From: Hannah Riddle on behalf of Planning.Responses
Sent: 26 April 2022 16:30
To: Planning Scanning
Subject: FW: Planning Consultation on: BN/21/22/PL

Engineers Comments Regarding Surface Water Drainage

Application No: BN/21/22/PL
Registered: 10th March 2022
Site Address: The Hollies 84 Barnham Road Eastergate PO22 0ES
Grid Reference: 495759 104587
Description of Works: Demolition of existing care home and construction of 5 no. dwellings and garaging, with landscaping and associated works. This application affects the setting of a listed building and is in CIL Zone 2 and is CIL Liable as new dwellings.

7.2 **Appendix B – Drainage Layout**

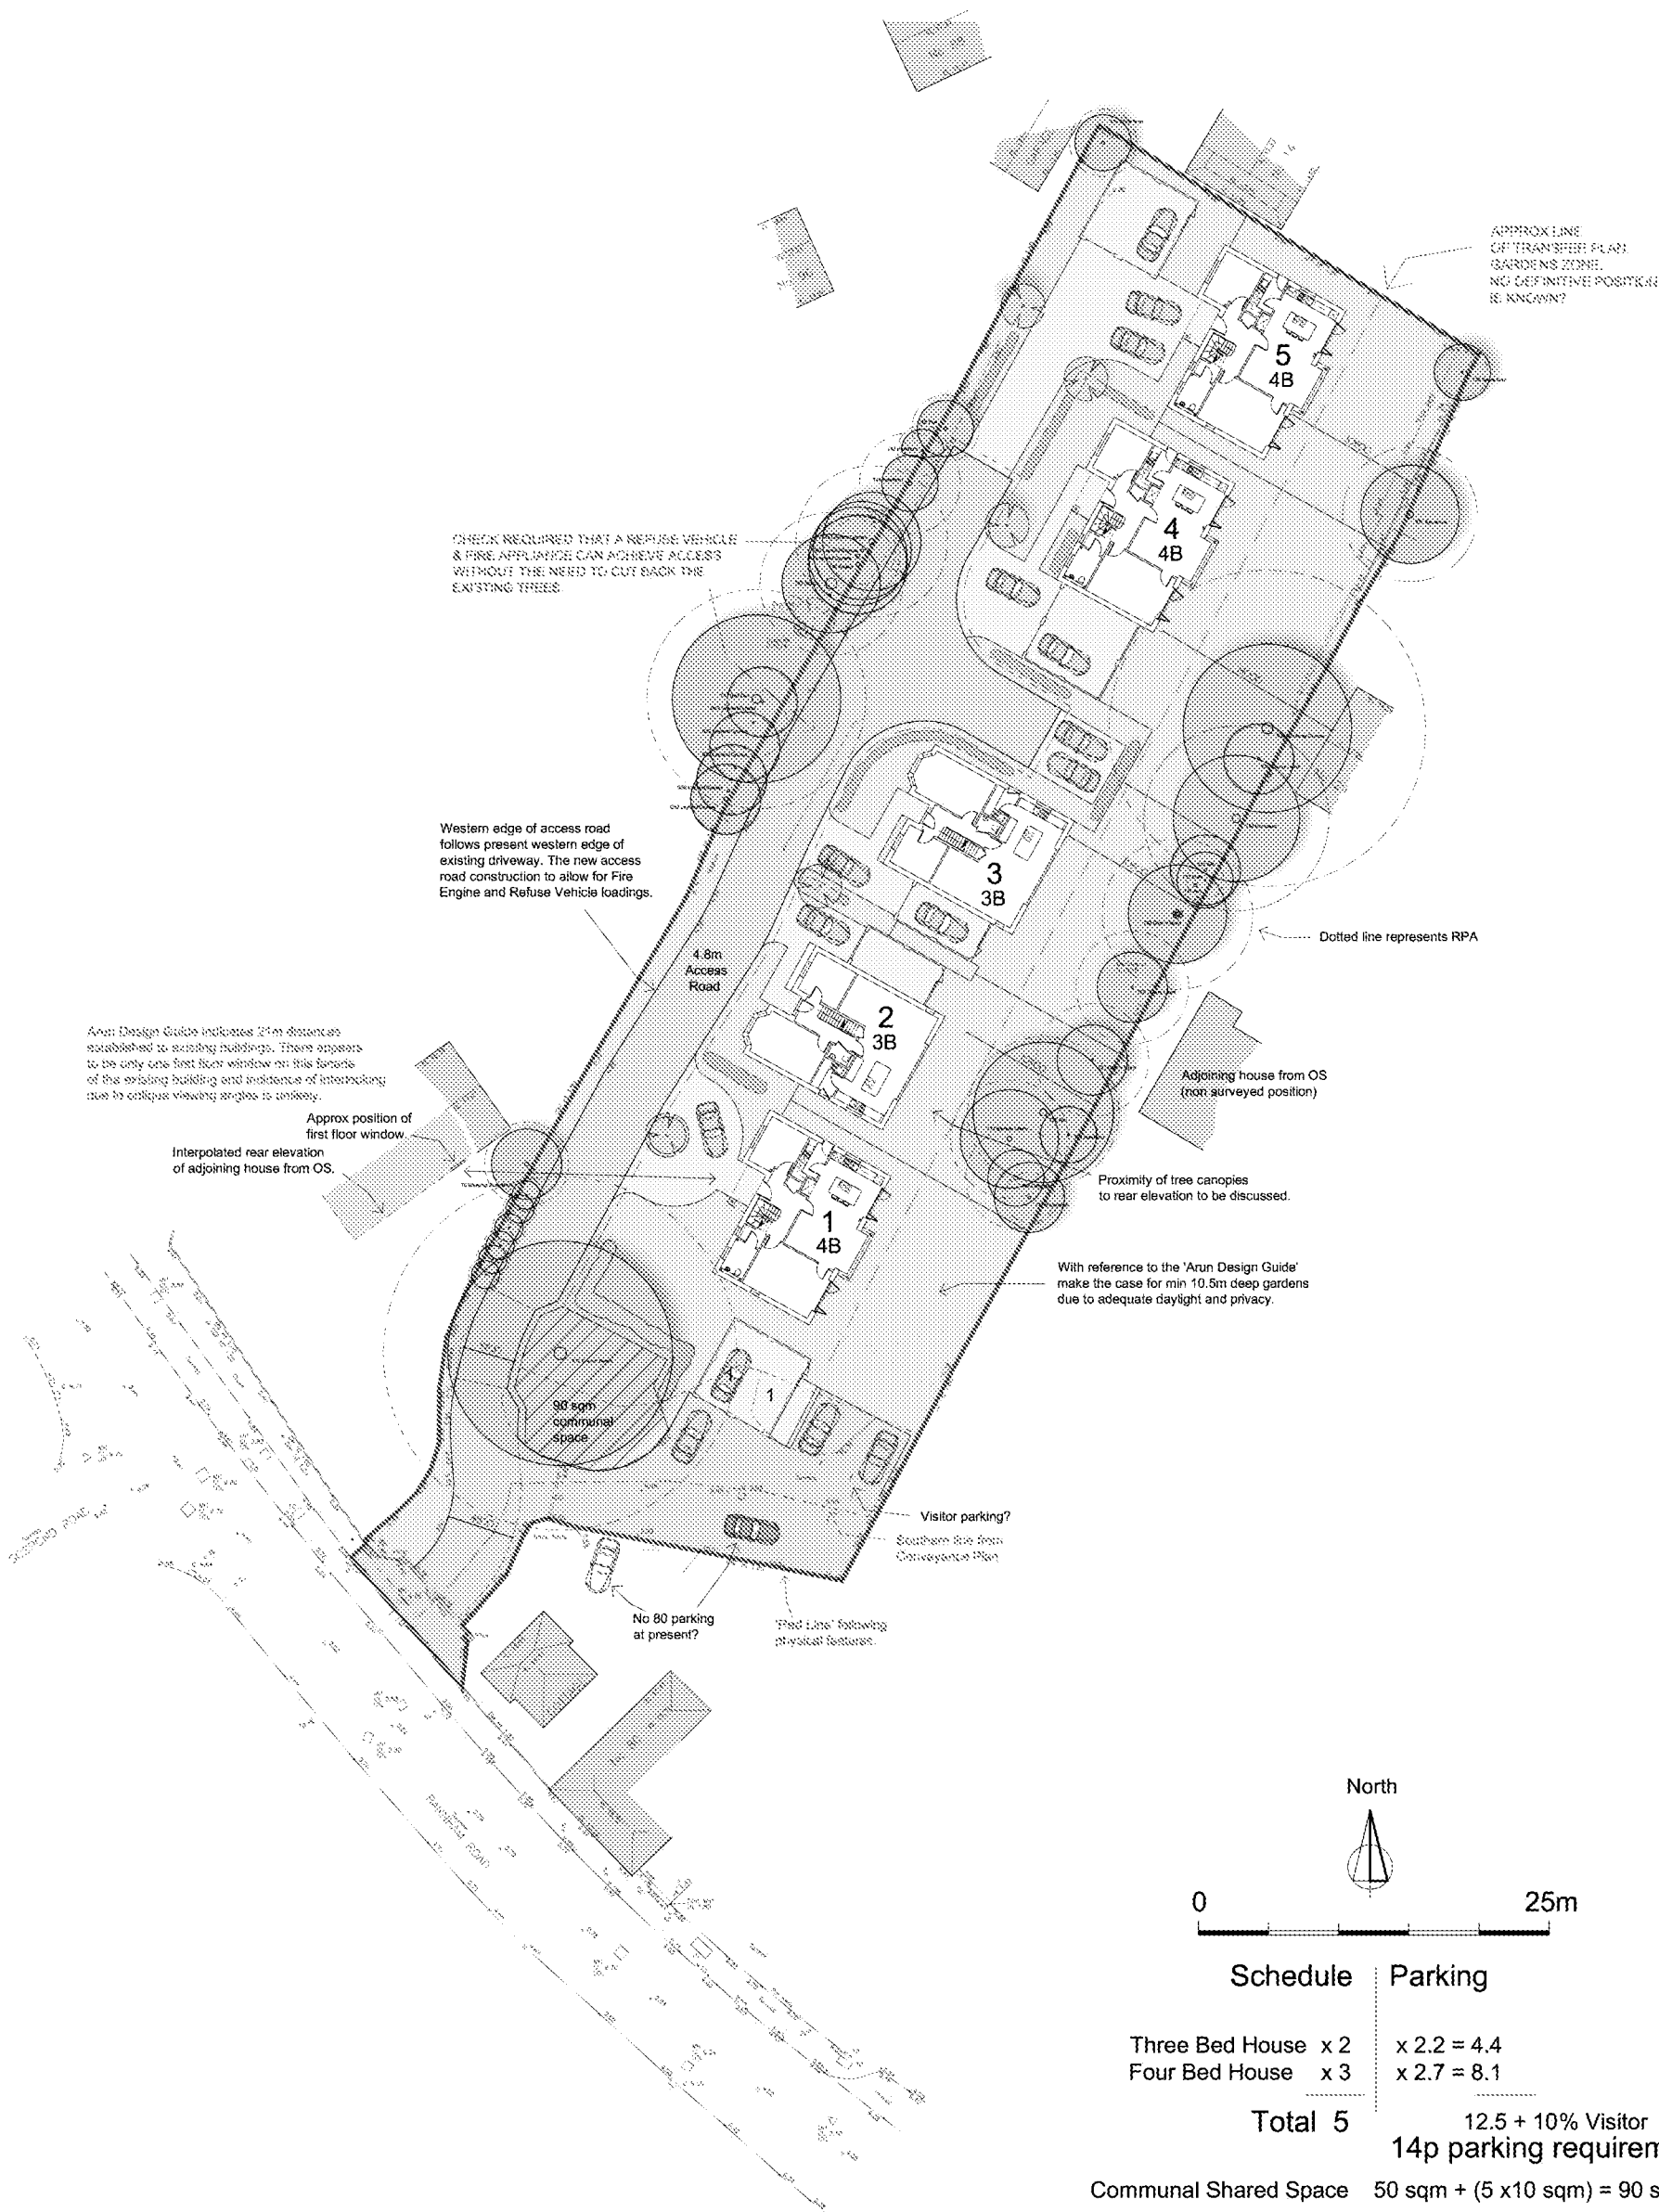
Existing and proposed trees (root protection zones) must not conflict with suds features/pipework. The tree officer would need to be consulted about the proposals for permeable paving installed with no dig construction in tree root protection areas when a discharge of conditions application is made (if the application is approved).

The applicant has supplied a foul and surface water drainage strategy report which includes a preliminary drainage design showing that the applicant intends to drain surface water for the site via the permeable paving in the access drive. The design is based upon an assumed infiltration rate as no winter groundwater monitoring or winter infiltration testing have been undertaken to date. These will be necessary to inform the detailed design.

Whilst the infiltration rate may prove to be slower than the assumed rate, there is scope within the design to increase the capacity of the permeable paving by using crates (rather than granular fill). Therefore, I have no objection to the application. Alterations will need to be made to the design parameters and more detailed plans, including an impermeable area plan, will need to be supplied at a later date.
